Please ask for: Ms Iqraa Malik
Email: iqraa.malik@terraquest.co.uk
Telephone: 01212341390
Our Ref: AL/24/21/HH
Your Ref:
Date: 1st March 2021

Application for Planning Permission for Works or Extension to a Dwelling

Development: Proposed detached double garage
Location: Barnside Hook Lane Aldingbourne PO20 3TE

SITE PLAN 1:500
(showing track of car
turning through 90°)

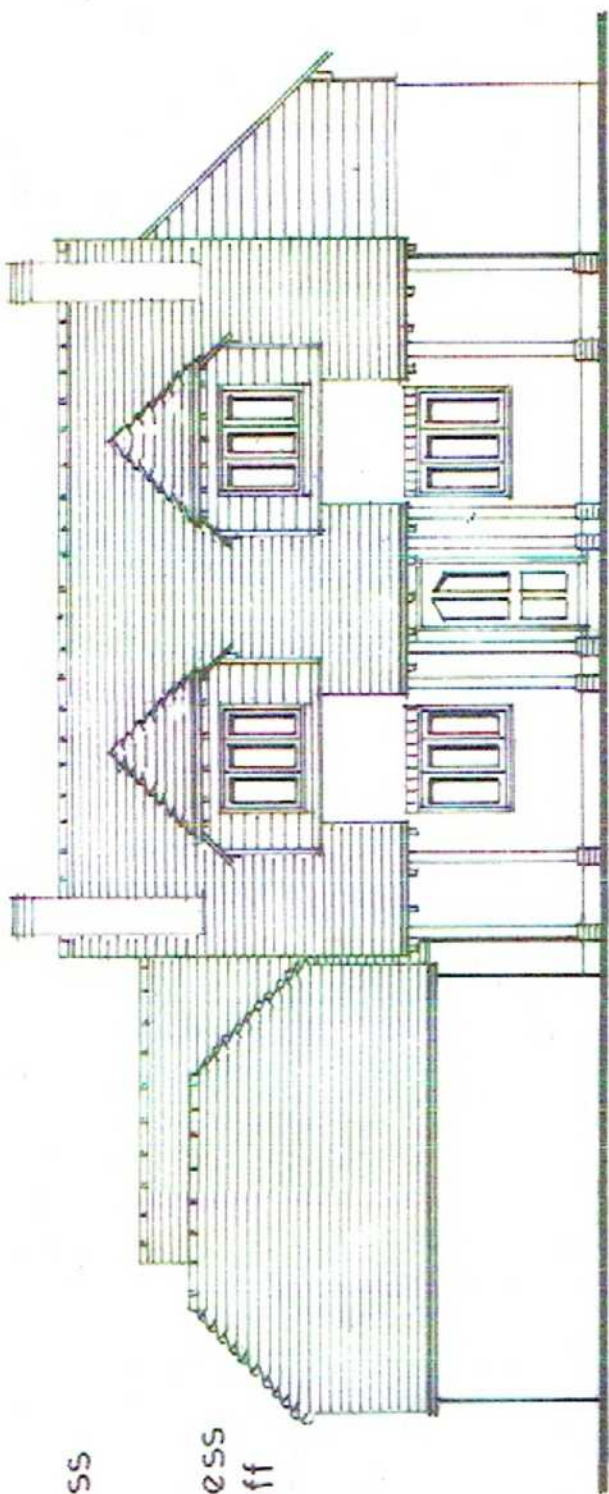
Dimensions: You are required to include dimensions from the proposed garage to all site boundaries.
